GEOSCAPES Reference: # 231107\_SSD\_LET\_RTC01

Re: **Glendenning Road Data Centre, 2 Glendenning Rd, Glendenning NSW 2761 (SSDA 73761707) - Response to Submissions – Landscaping and Visual Impact.**

Please find below our responses to recent comments raised by the DPHI regarding the Landscape Plans and VIA prepared by Geoscapes for the above-named project.

PROJECT: GLENDENNING ROAD DATA CENTRE
TITLE: CANOPY COVER PLAN
DRAWING: GRC026-GEO-00-XX-DR-SSDA-L-0002
PAPER SIZE: SCALE: 1:500 @ A0
AGILE NO: G
REV: G
PRINT IN COLOUR

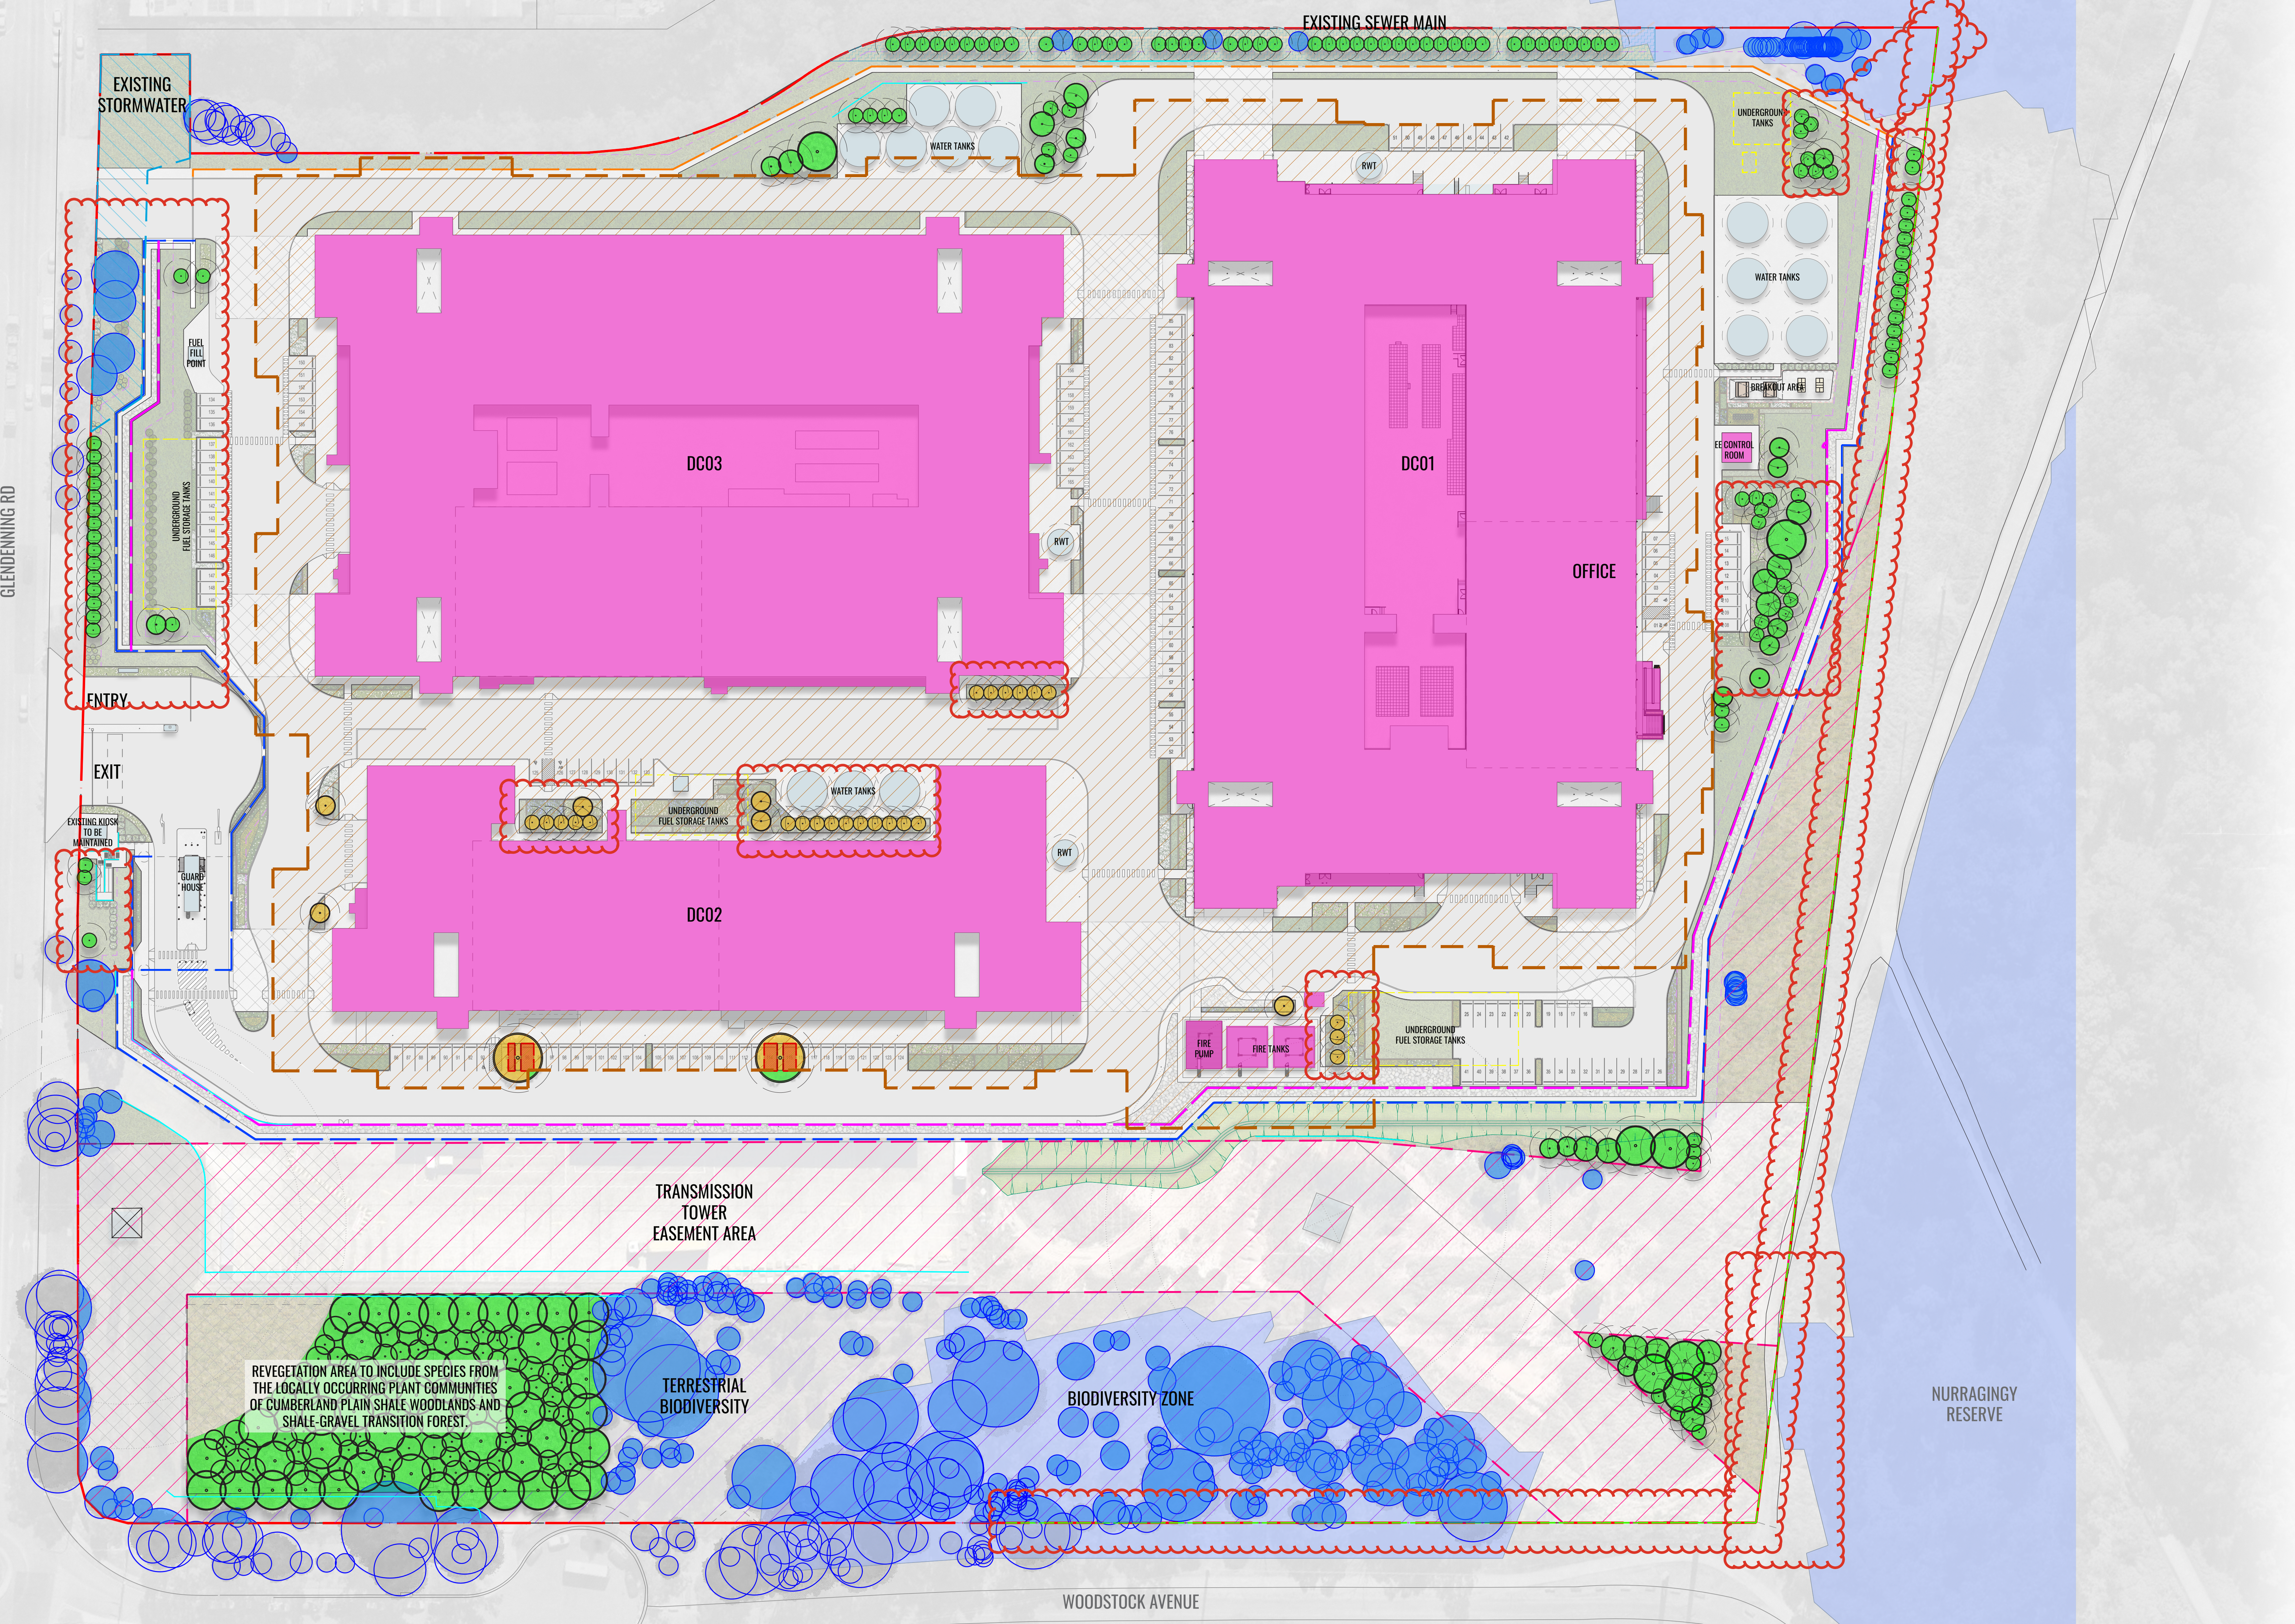
- Tree canopy cover should be less than 15% at maturity

- Trees at maturity should not touch or overhang the building

- Tree canopies should be separated by 2 to 5 m

- Shrubs should not be located under trees

- *Landscape species are chosen to ensure tree canopy cover is less than 15% (IPA) at maturity and trees do not touch or overhang buildings*

**Geoscapes Response** – Refer to Canopy Cover Plan on L-0002, total tree canopy cover across the site is 10%, within APZ identified zones this reduces to 1.78%

**Geoscapes Response** – Refer to Canopy Cover Plan on L-0002, a 2 m offset from mature tree canopies has been applied for all trees located near buildings.

**Geoscapes Response** – Landscape plans have been reviewed and endorsed by the project Bushfire Consultant. Refer to Canopy Cover Plan on L-0002, a 2 m offset from the mature tree canopy has been applied for all trees. While some trees are planted in groups, the 2 m offset still applies to the canopy of the trees located at the outer edge of each group.

**Geoscapes Response** – Refer to Canopy Cover Plan on L-0002 and Detail Plan on L-0100 to L-0103; no shrubs have been provided under trees within the APZ. Landscaping adjacent to service areas, previously proposed as shrubs, has been revised to groundcover. Shrubs are present under trees within M1 (frontage) and M3A (revegetation area); however, these locations are outside the APZ, so the restriction does not apply.

**Geoscapes Response** – Refer to Canopy Cover Plan on L-0002, total tree canopy cover is 10% (within APZ zones this reduces to 1.5%). A 2 m offset from the mature tree canopy has been applied for all trees located near the building.

TITLE: PROPOSED TREE LOCATIONS & SERVICES PLAN OVERLAY

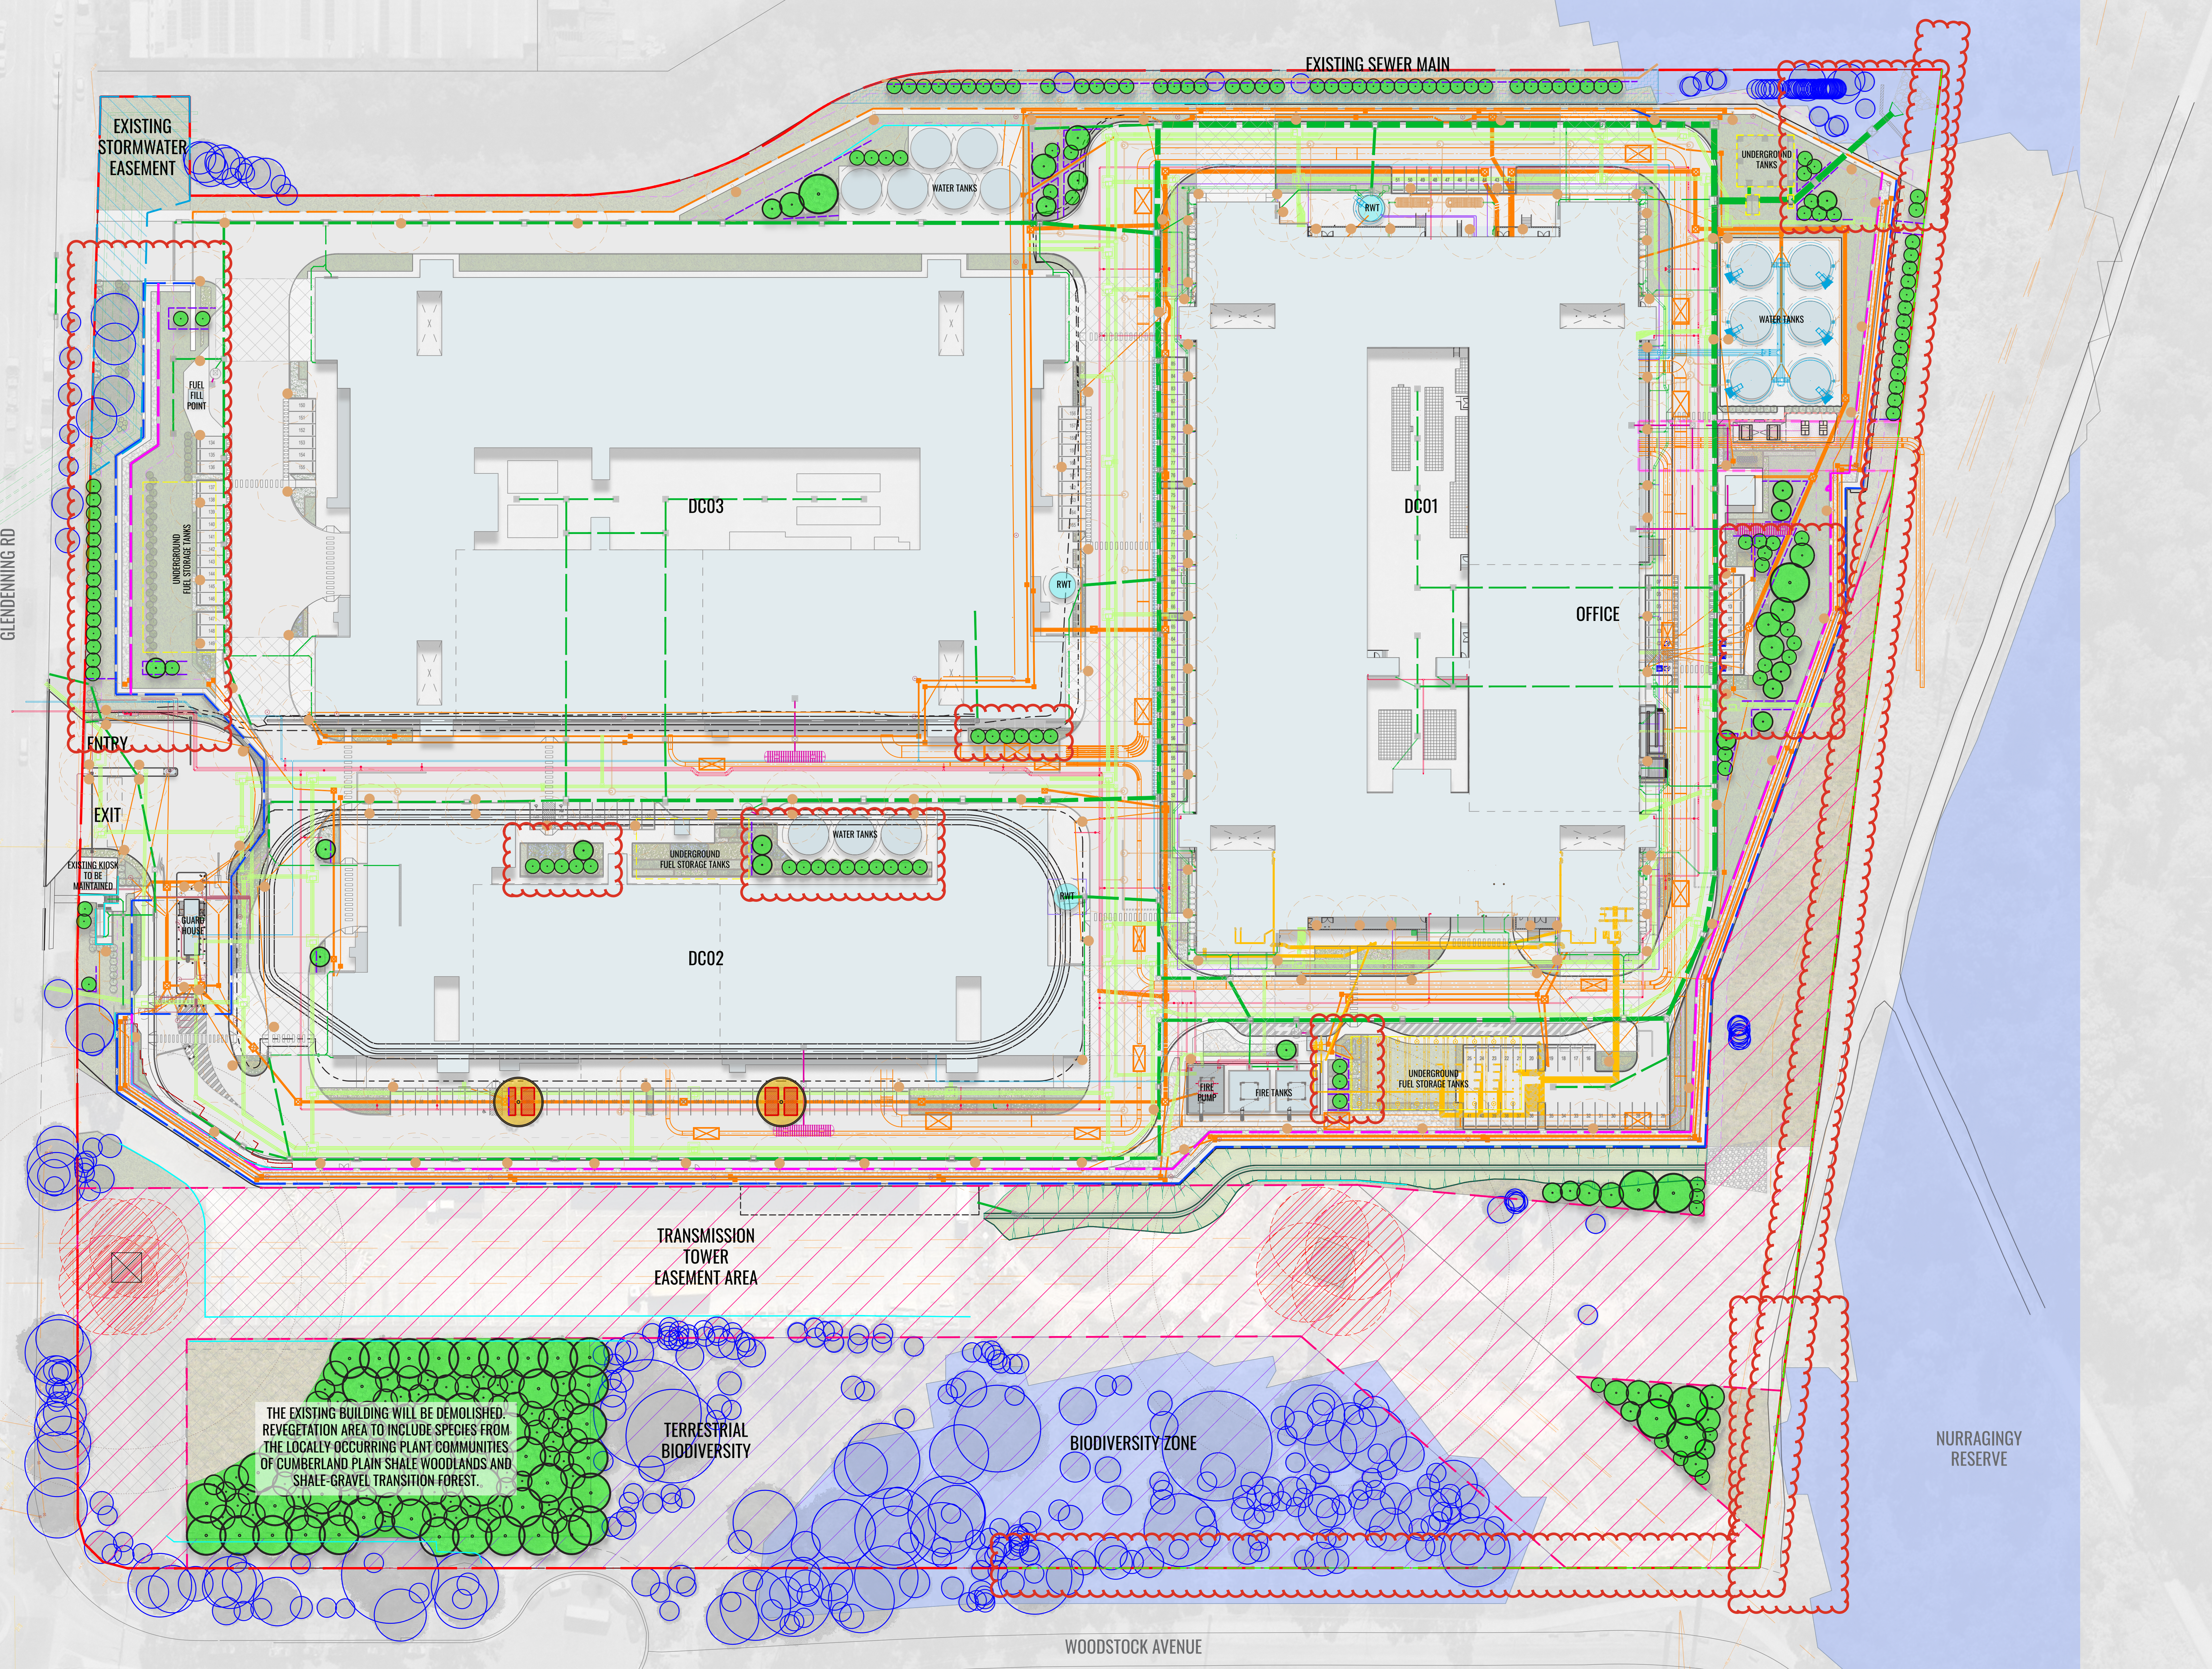
*d. Provide additional landscaping and tree planting in the front landscaped setback area adjacent Glendenning Road. Underground fuel tanks are also proposed in the landscape setback which compromises the opportunity for dense landscaping in the front setback. These tanks should be relocated accordingly.*

23. The Department shares Council's concerns regarding the placement of underground fuel storage tanks within landscaped areas, as this may limit the site's capacity to accommodate additional deep soil tree planting. The Department requests that the proposed location of the underground fuel tanks be reconsidered to optimise opportunities for deep soil planting and to ensure the provision of appropriate landscaped setbacks and buffers across the site.

**Geoscapes Response** – Refer to Proposed Tree Locations & Services Plan Overlay on L-0003. Landscaping in this area is constrained by underground services and the placement of underground fuel tanks. Refer to Detail Plan on L-0100 and Section A-A on L-0200. To address this, the following changes have been made:

- One *Elaeocarpus reticulatus prima donna* tree has been replaced with a larger species; *Cupaniopsis anacardioides*.
- 1-3 m tall shrubs have been introduced to create denser landscaping in the front setback.

**Geoscapes Response** – Refer to Proposed Tree Locations & Services Plan Overlay on L-0003. Landscaping in this area is constrained by underground services and the placement of underground fuel tanks. Refer to Detail Plan on L-0100 and Section A-A on L-0200. To address this, the following changes have been made:

- One *Elaeocarpus reticulatus prima donna* tree has been replaced with a larger species; *Cupaniopsis anacardioides*.
- 1-3 m tall shrubs have been introduced to create denser landscaping in the front setback.
